DECISION DELEGATED TO HEAD OF PLANNING

Application No: H08-0951-24 **Applicant:** Mr R Bennett
Proposal: Proposed car port
Location: Oak Lodge Cheal Road Gosberton
Terminal Date: 9th January 2025

Site plan

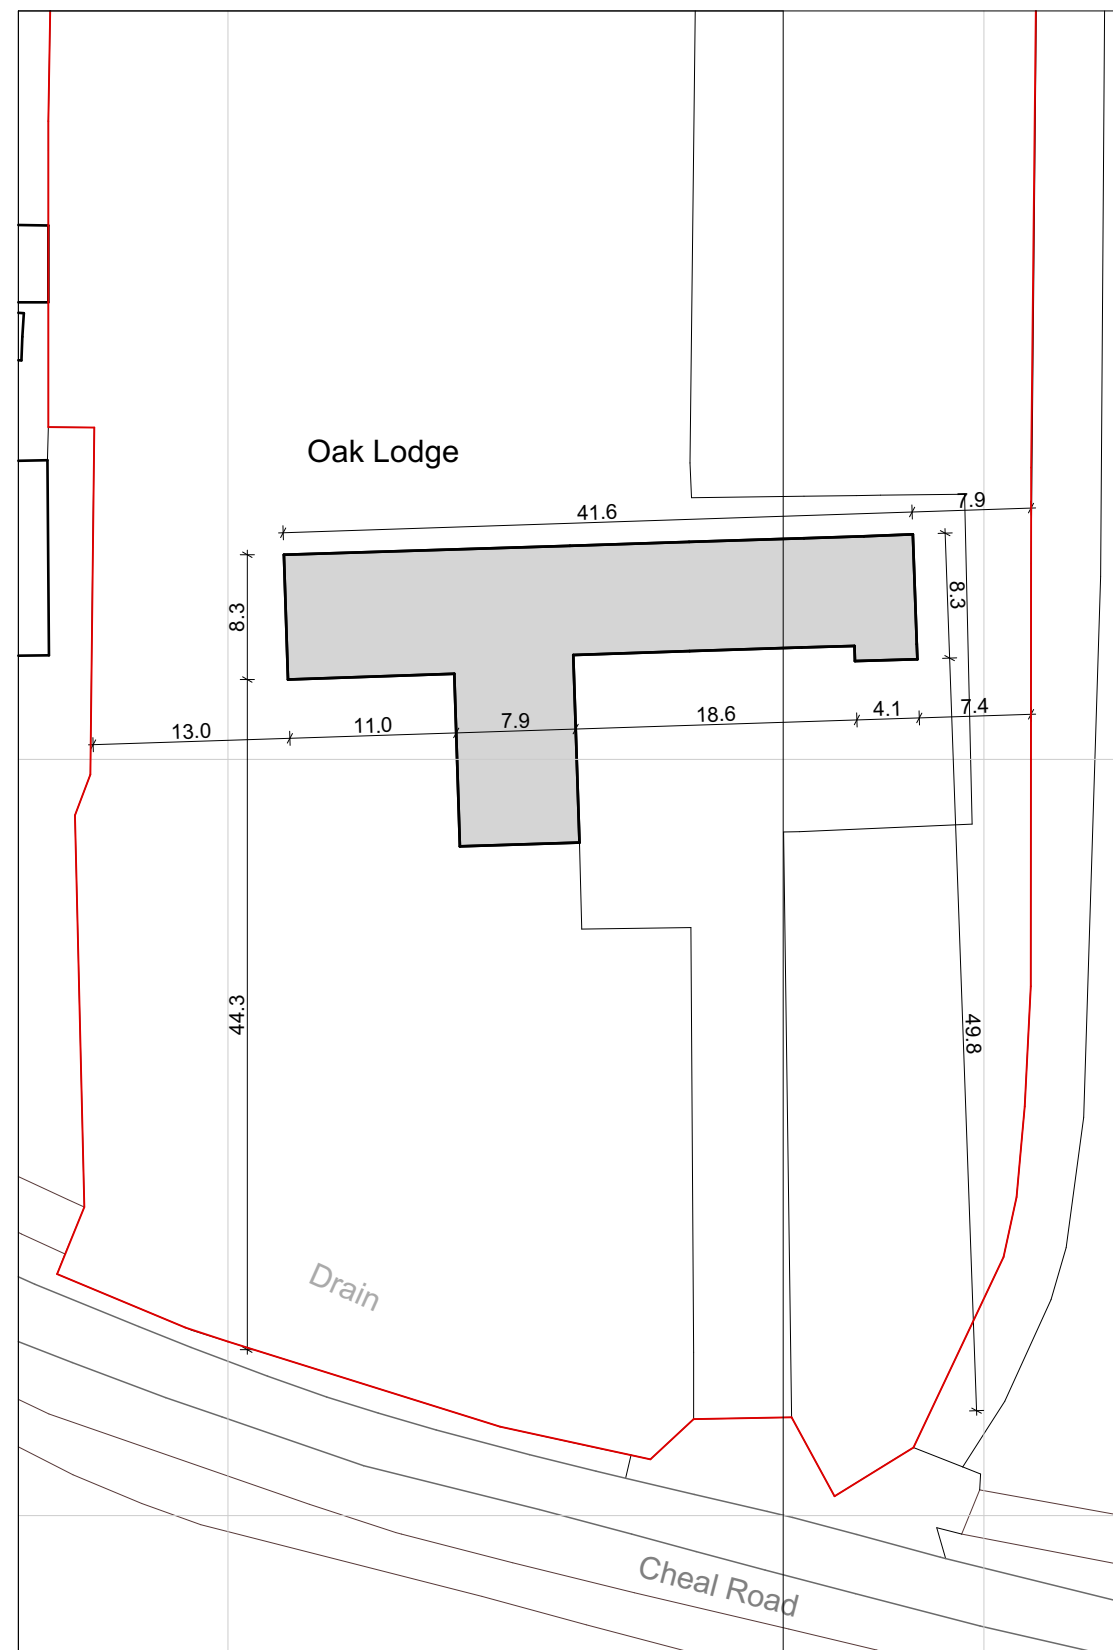
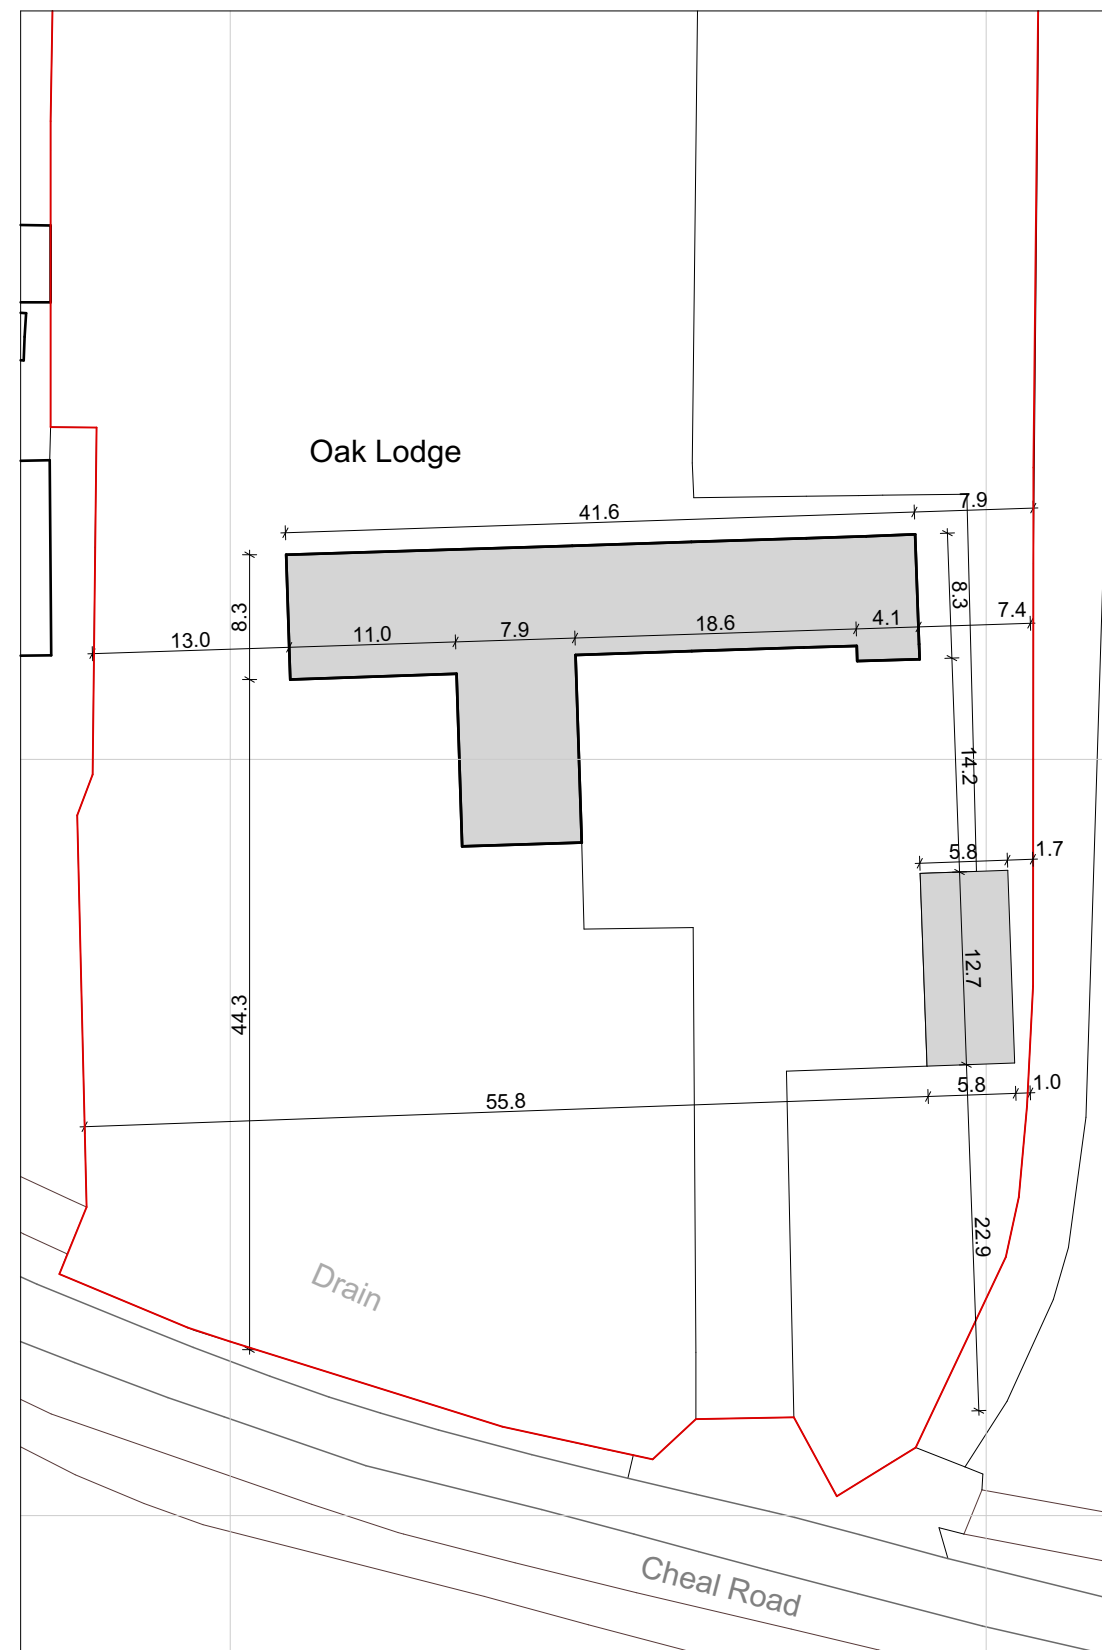
Finally, it would be positioned to the front of the site, around 14m from the front elevation of Oak Lodge itself and around 22.9m from the highway. Whilst it could be considered to look somewhat at odds and out of place as there are no other outbuildings/car ports to the front of other sites, due to it being set back some distance from the road and within the residential curtilage, it would not create unacceptable material harm on the street scene or locality in this instance. This is therefore acceptable.

PROPOSED ELEVATIONS

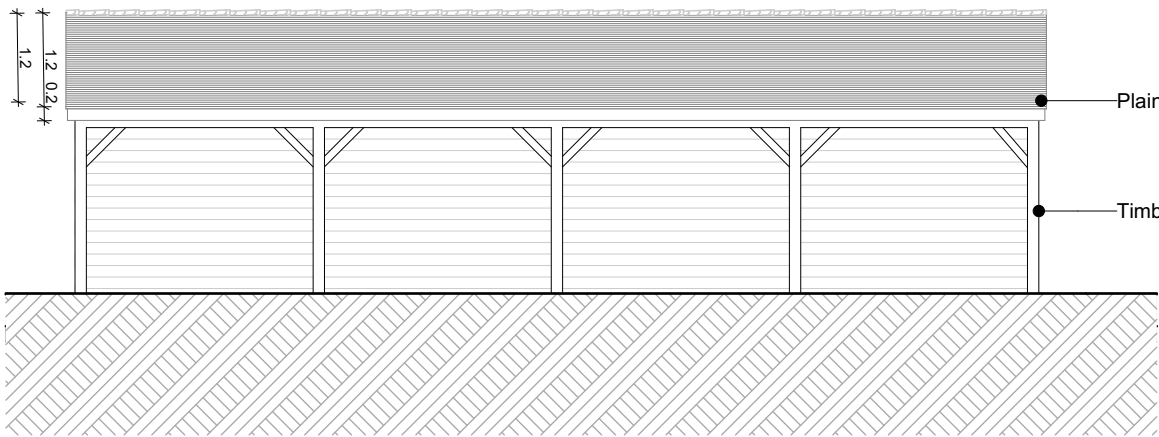
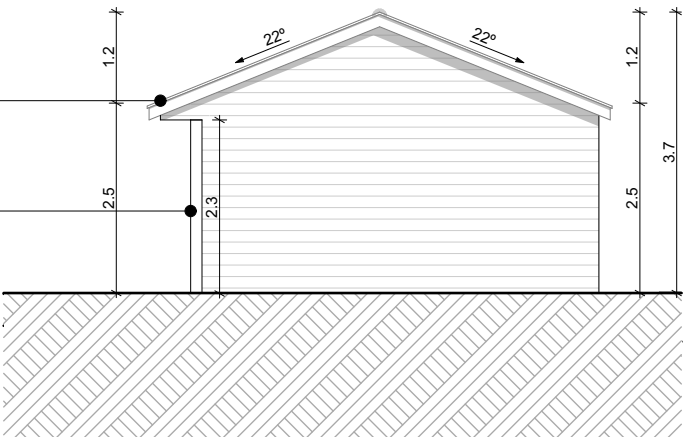
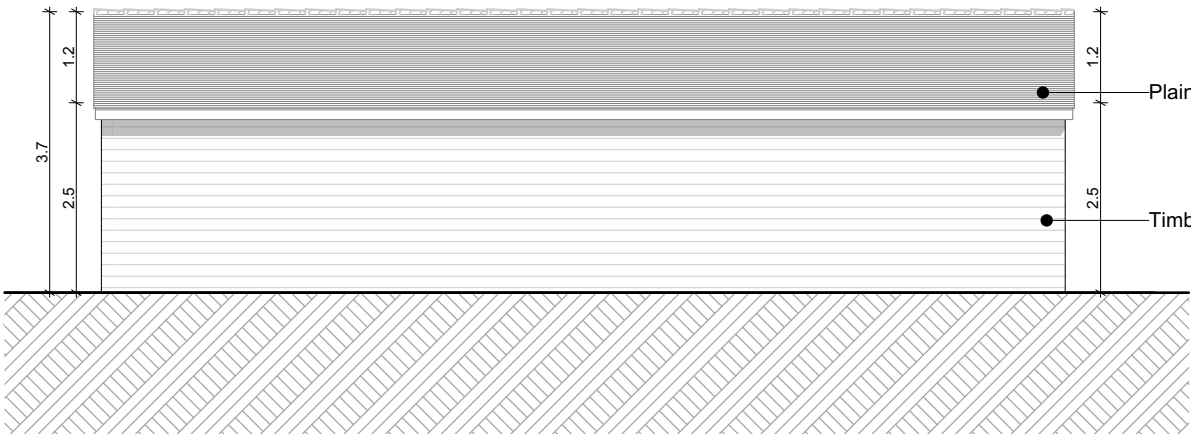
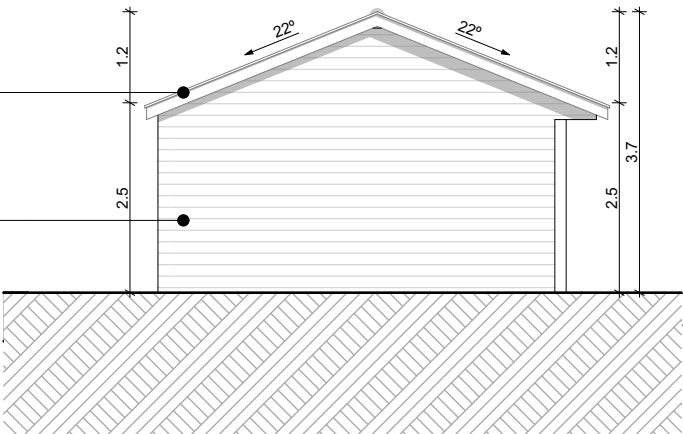
The materials of the car port are as follows, the walls would be made from timber weather boarding and the roof would be plain tiles. These are fairly standard materials for a development of this kind, whilst they may not necessarily be in keeping with anything in the immediate area, it would not cause any material harm.

In total, it will be 5.4m wide and 12.7m long (approximately) and would have a total height of 3.7m and around 2.5m to the eaves. One side of the roof would overhang slightly with the front elevation open up for access. Again, this is of a standard design and size for a car port and is also considered to be acceptable.
